LSC RESPONSE TO COUNTY DPW COMMENTS

From: Bret Dilts
Sent: Wednesday, August 14, 2024 10:04 AM
To: Bill Guman <bill@guman.net>
Subject: El Paso Co Project PPR246 Meridian Ranch Sports Center

STORM SEWER PLAN

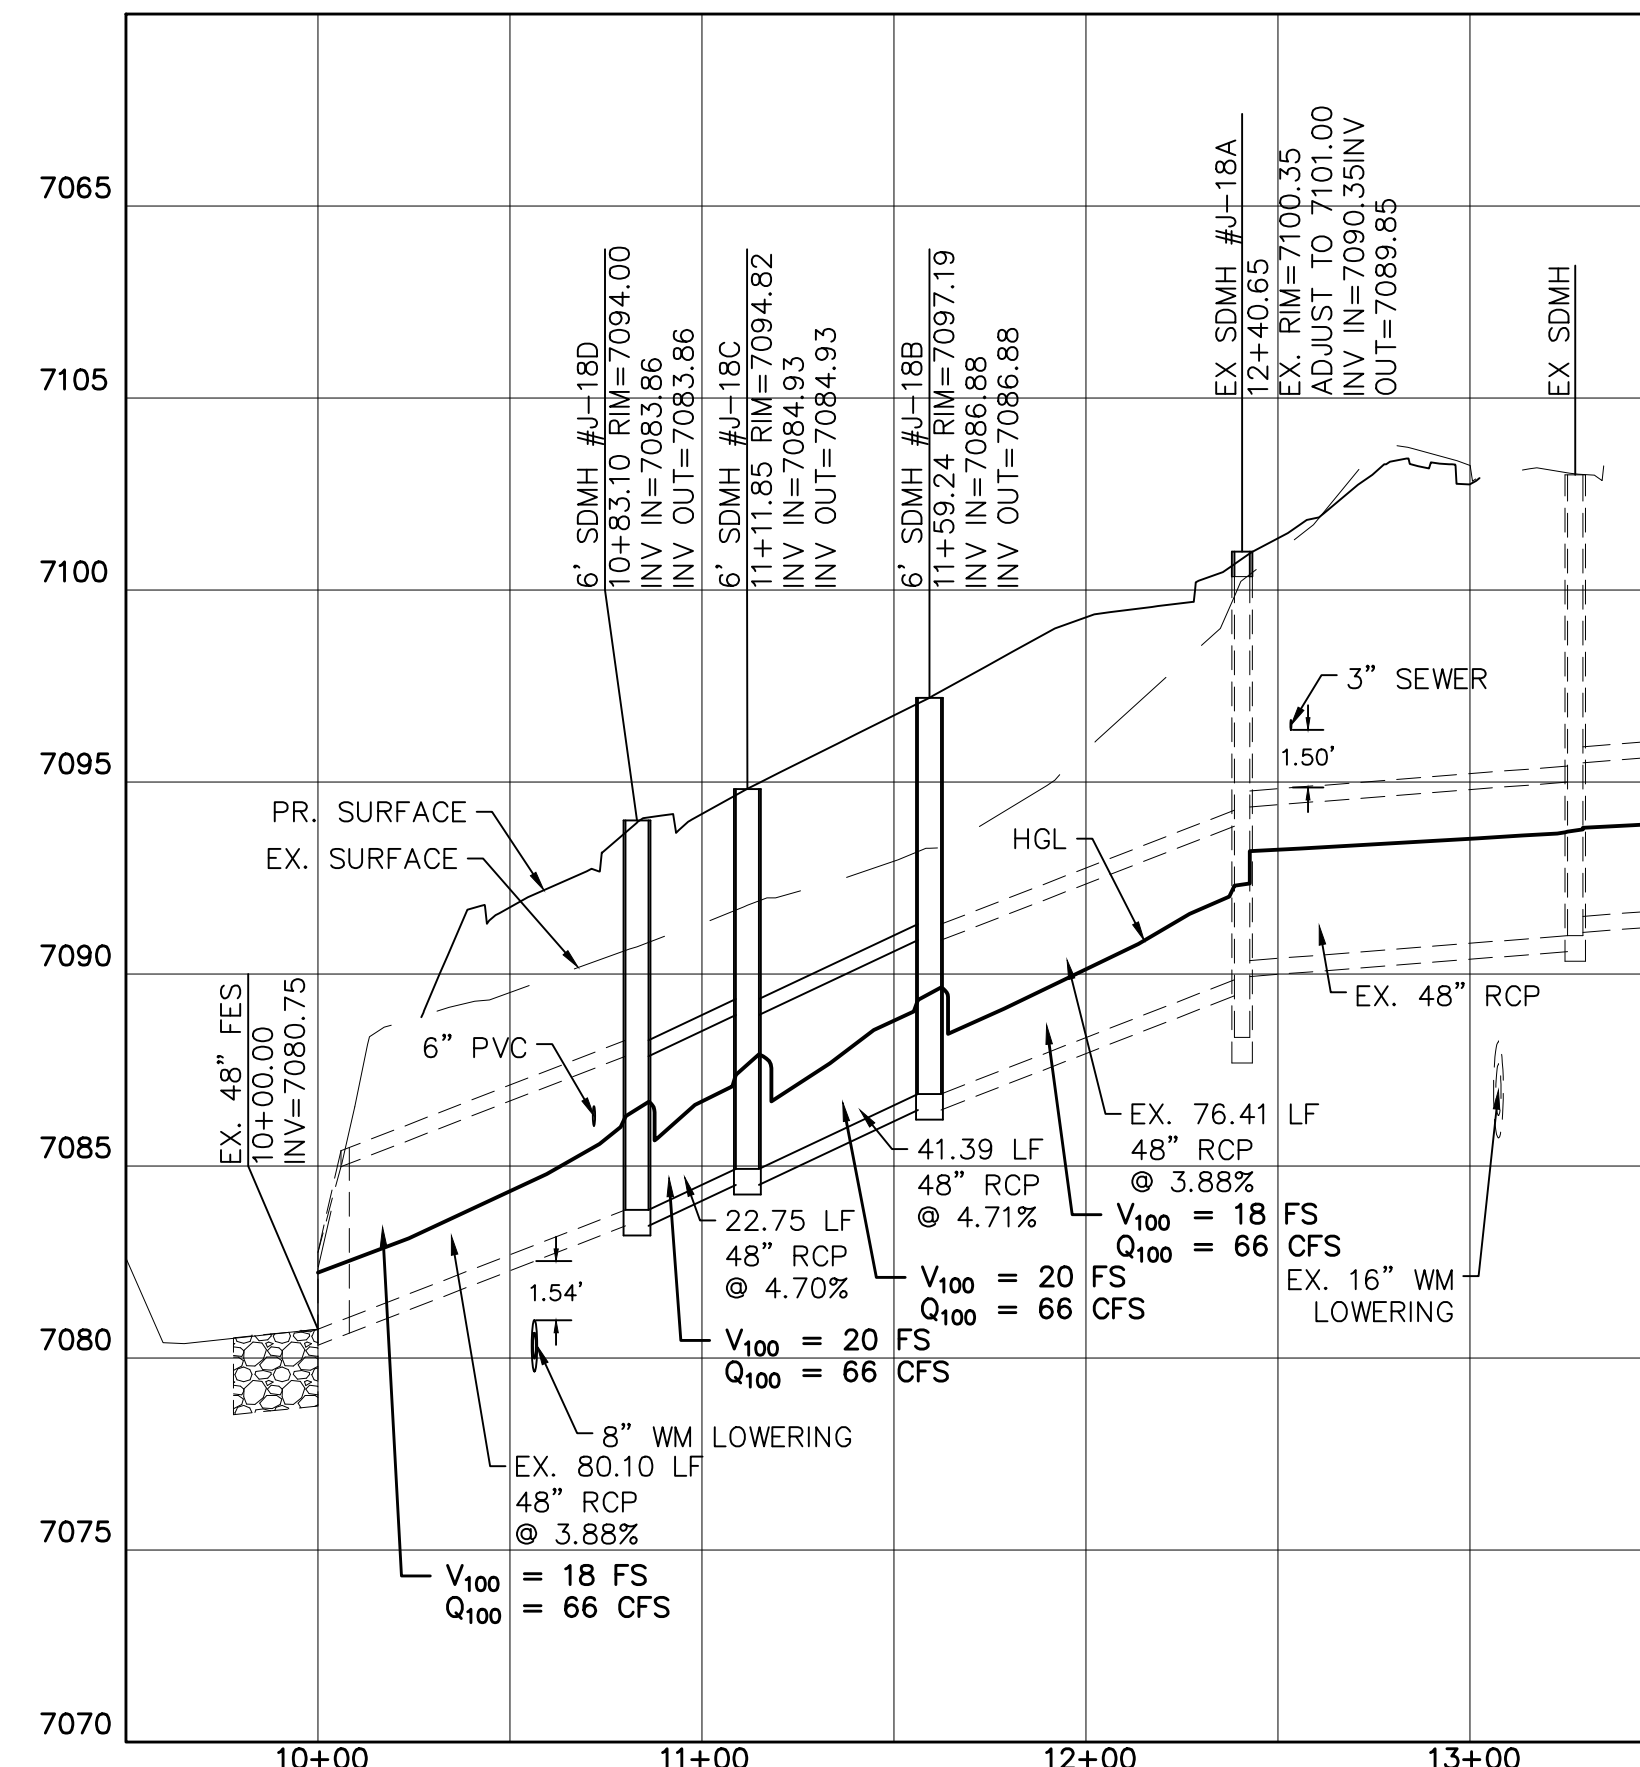
I would also like to request a note be added to the GEC plans to identify whether the storm pipes identified on the plan are County owned and maintained or privately owned. This includes the existing 48" RCP that runs under Rainbow Bridge Dr and outfalls in the drainage way. Management has requested this note be added to the plans prior to EPC acceptance.
